RESPONSE TO SUBMISSIONS – SSD 6513 MOD 3 BUILDING R1, BARANGAROO SOUTH

This letter has been prepared by Ethos Urban (formerly JBA) on behalf of Lend Lease Millers Point in relation to the section 96(1A) application (MOD 3) to modify SSD6513 being Building R1, Barangaroo South.

This letter provides a response to the submission made by the City of Sydney, dated 4 October 2017, and information requested by the Department of Planning and Environment (the Department) via email dated 3 October 2017. Each issue is addressed under separate heading below.

Ground Level Plan

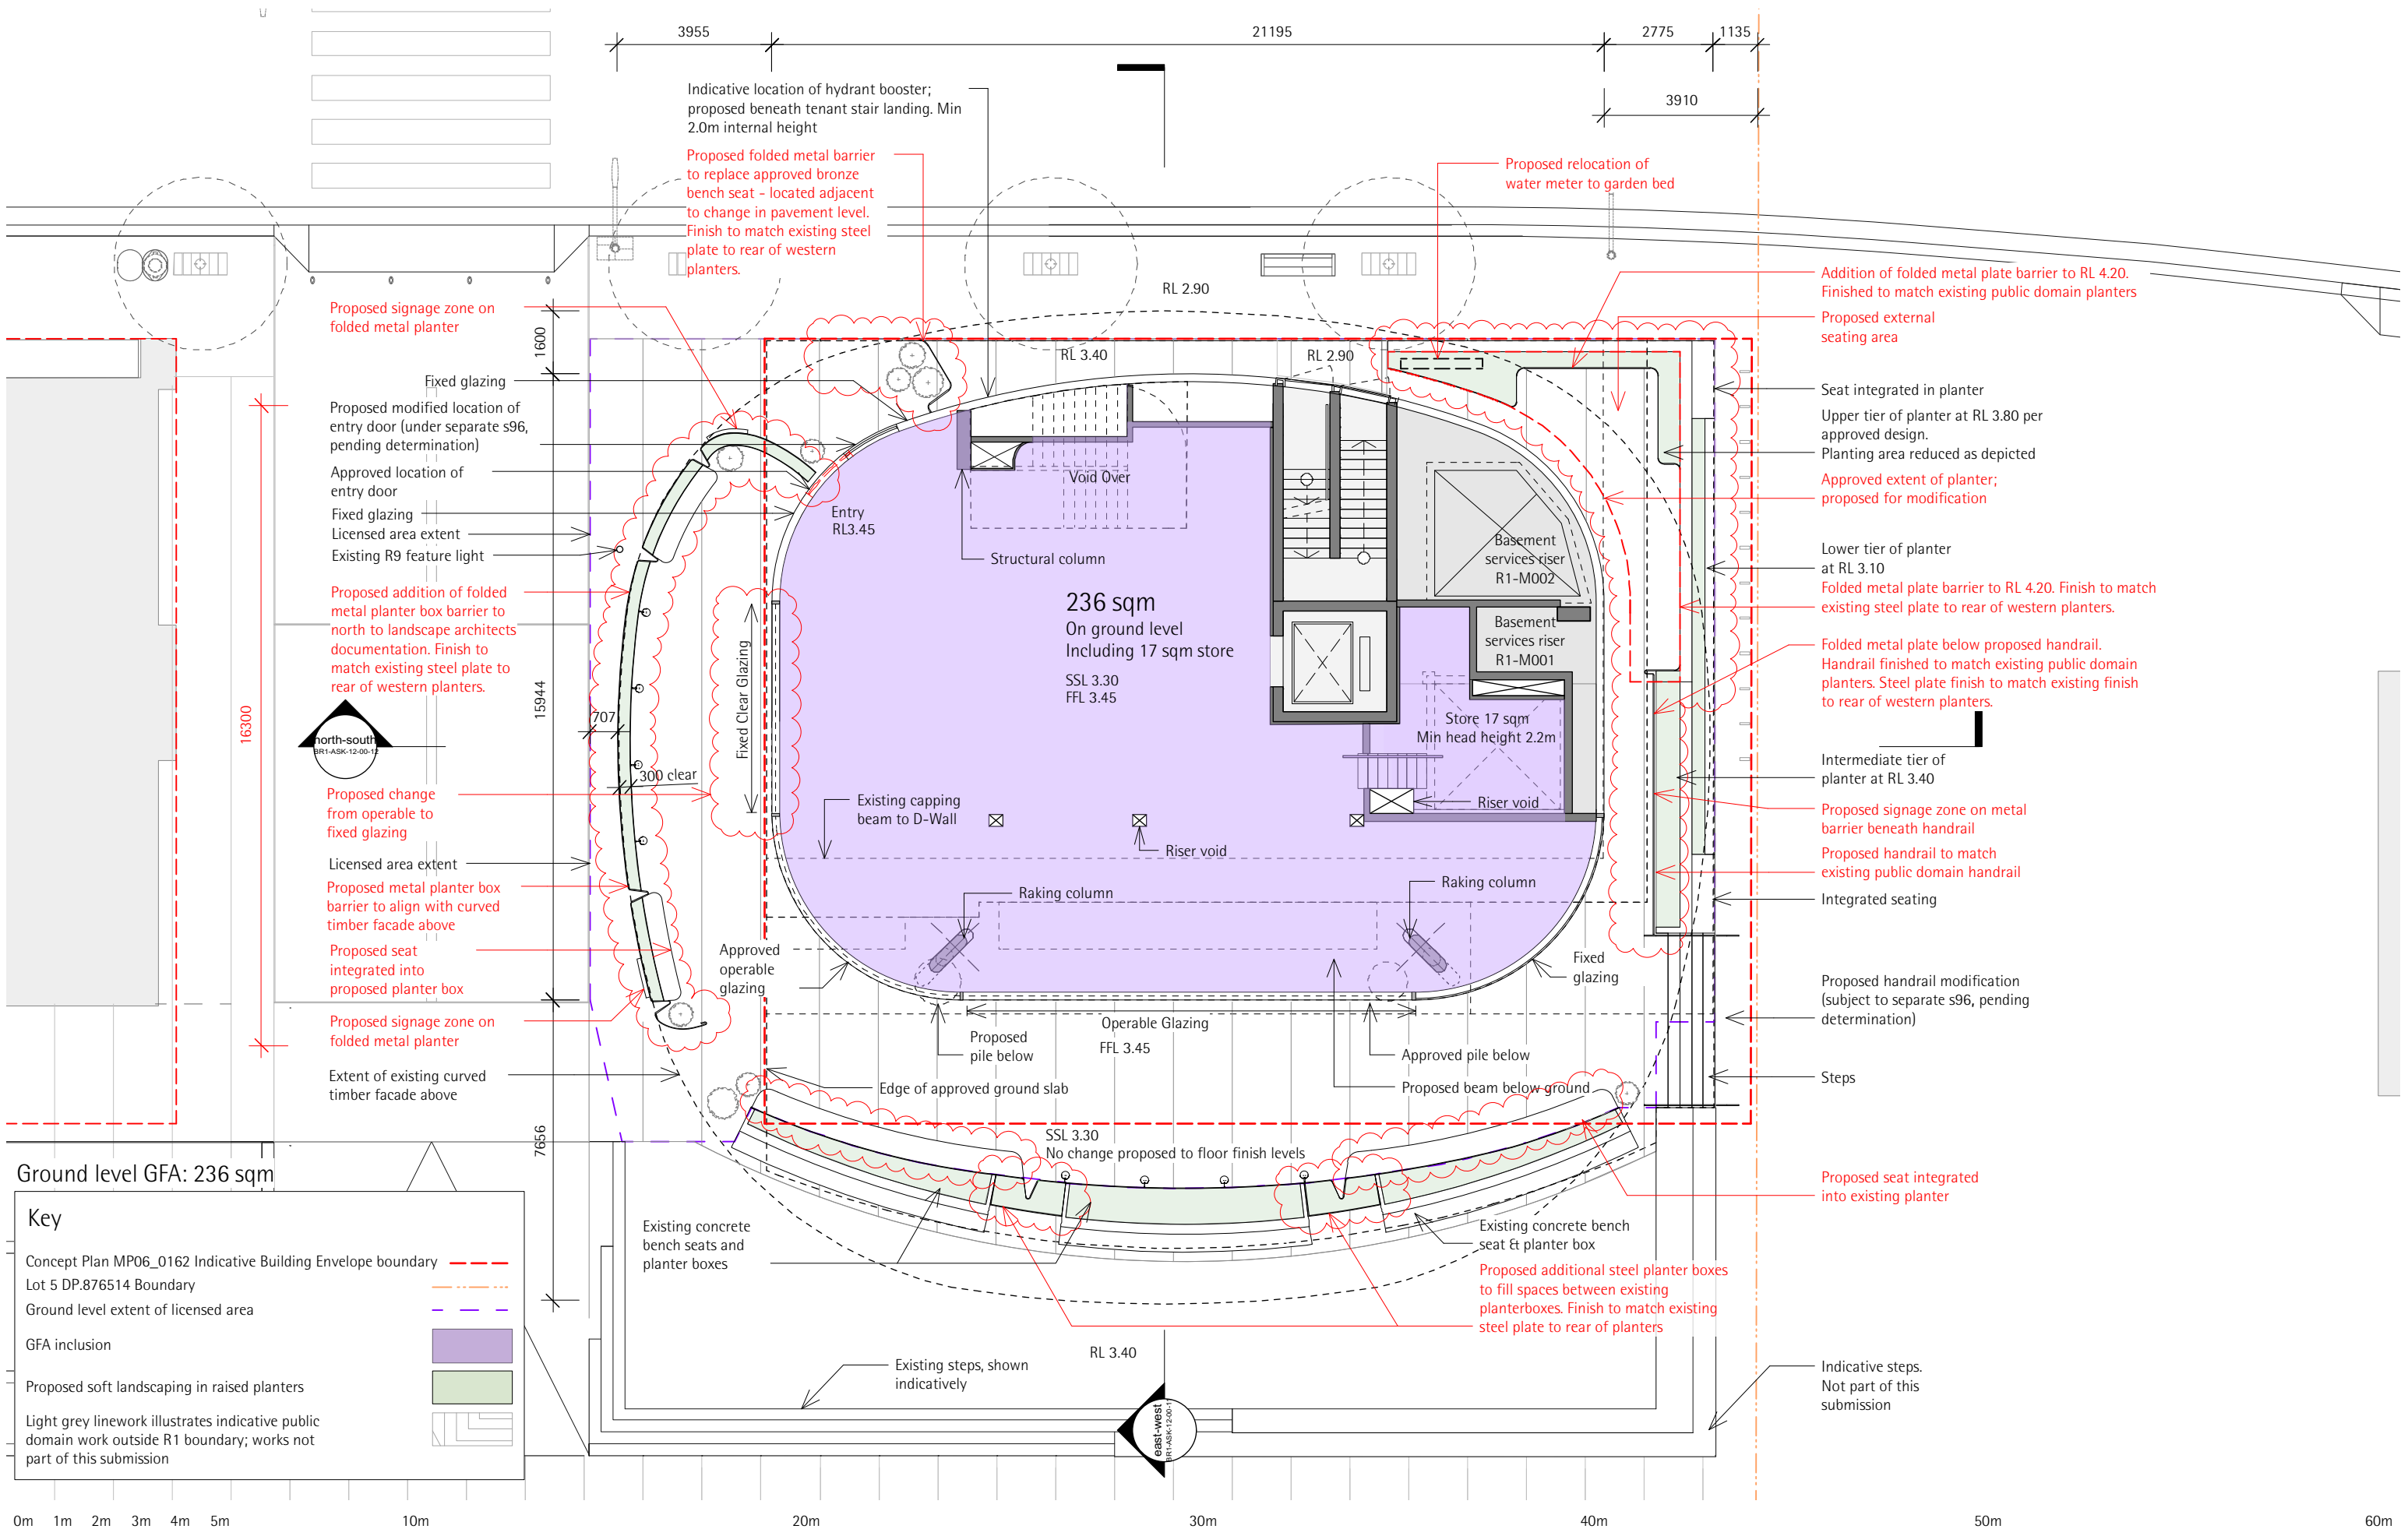
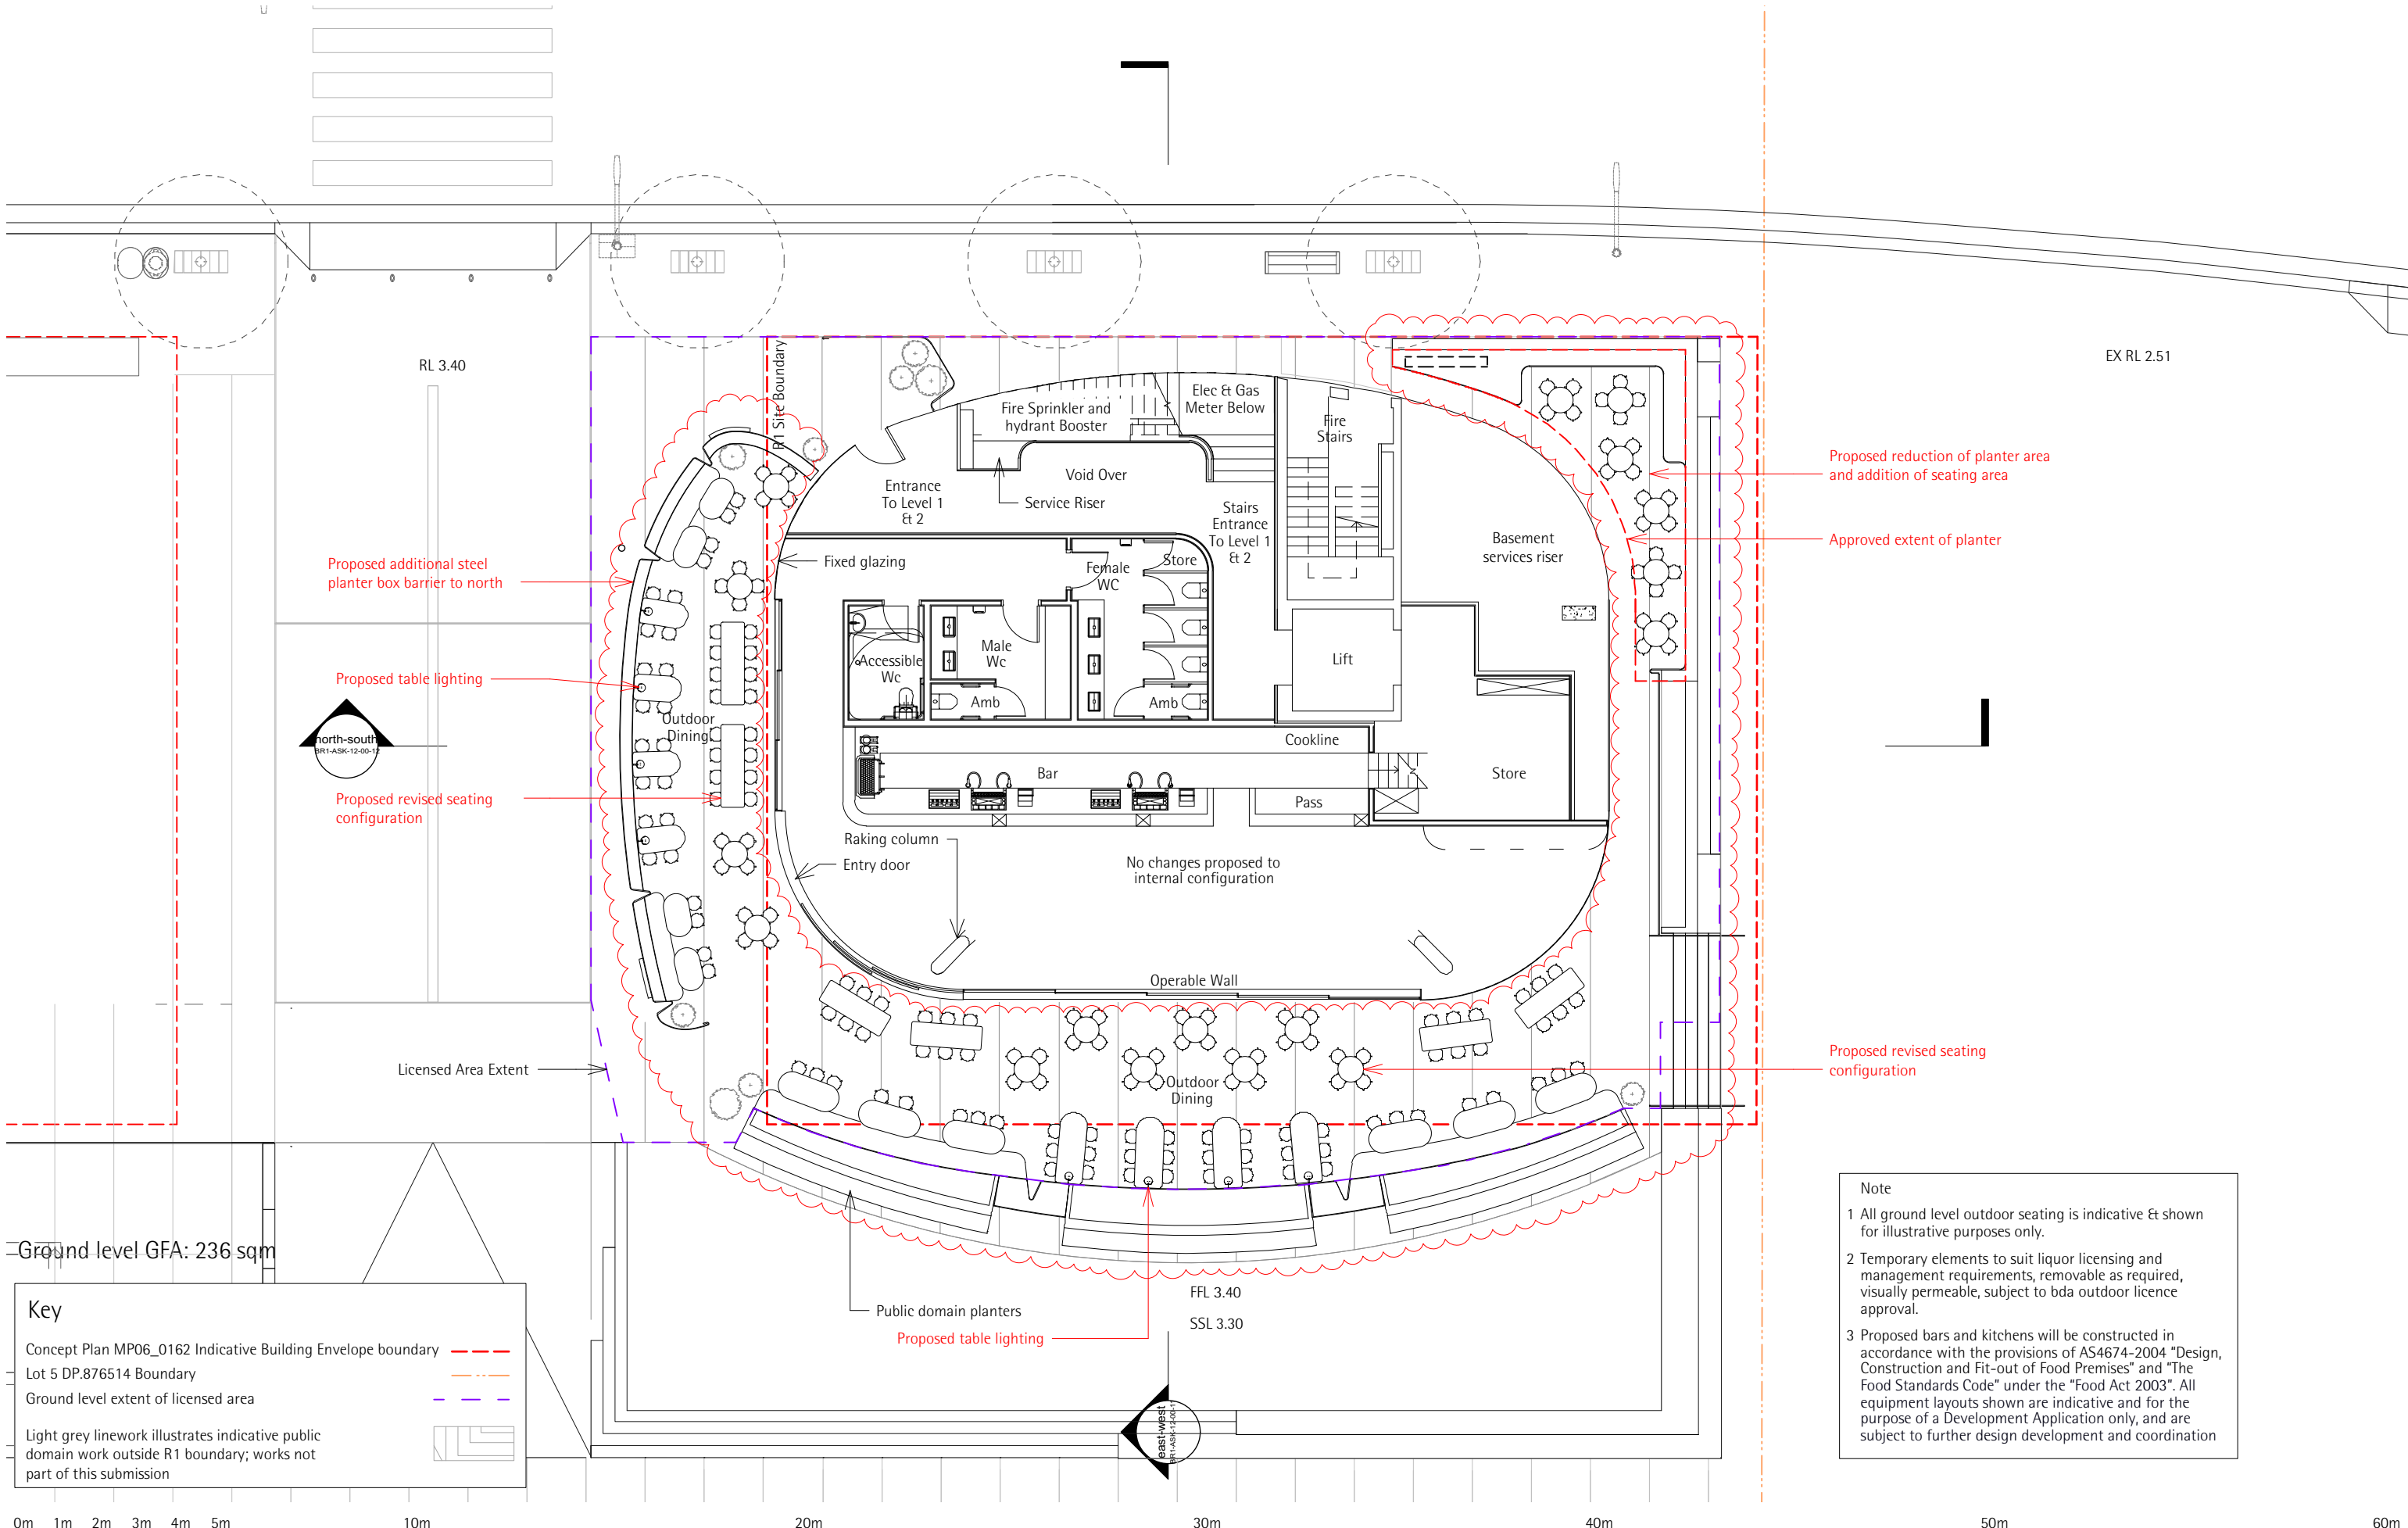
South-east Seating Area

The proposed south-east seating area has employed Crime Prevention Through Environmental Design (CPTED) principles as follows:

Although located separate to the primary outdoor seating area of Building R1, the proposed south-east seating area is in a highly visible location within the public domain of Barangaroo South, located at a key gateway to the precinct with limited screening. This opportunity for casual surveillance will reduce the likelihood of anti-social behaviour in this seating area.

The proposed folded metal planter will ensure the effective control of the seating space, separating this from the public domain of Barangaroo South. This will also limit the capacity of the area to ensure that it can be managed in a safe and efficient manner. The separation of public/private areas through a low height physical barrier demarcates areas without limiting opportunities for casual surveillance as discussed above.
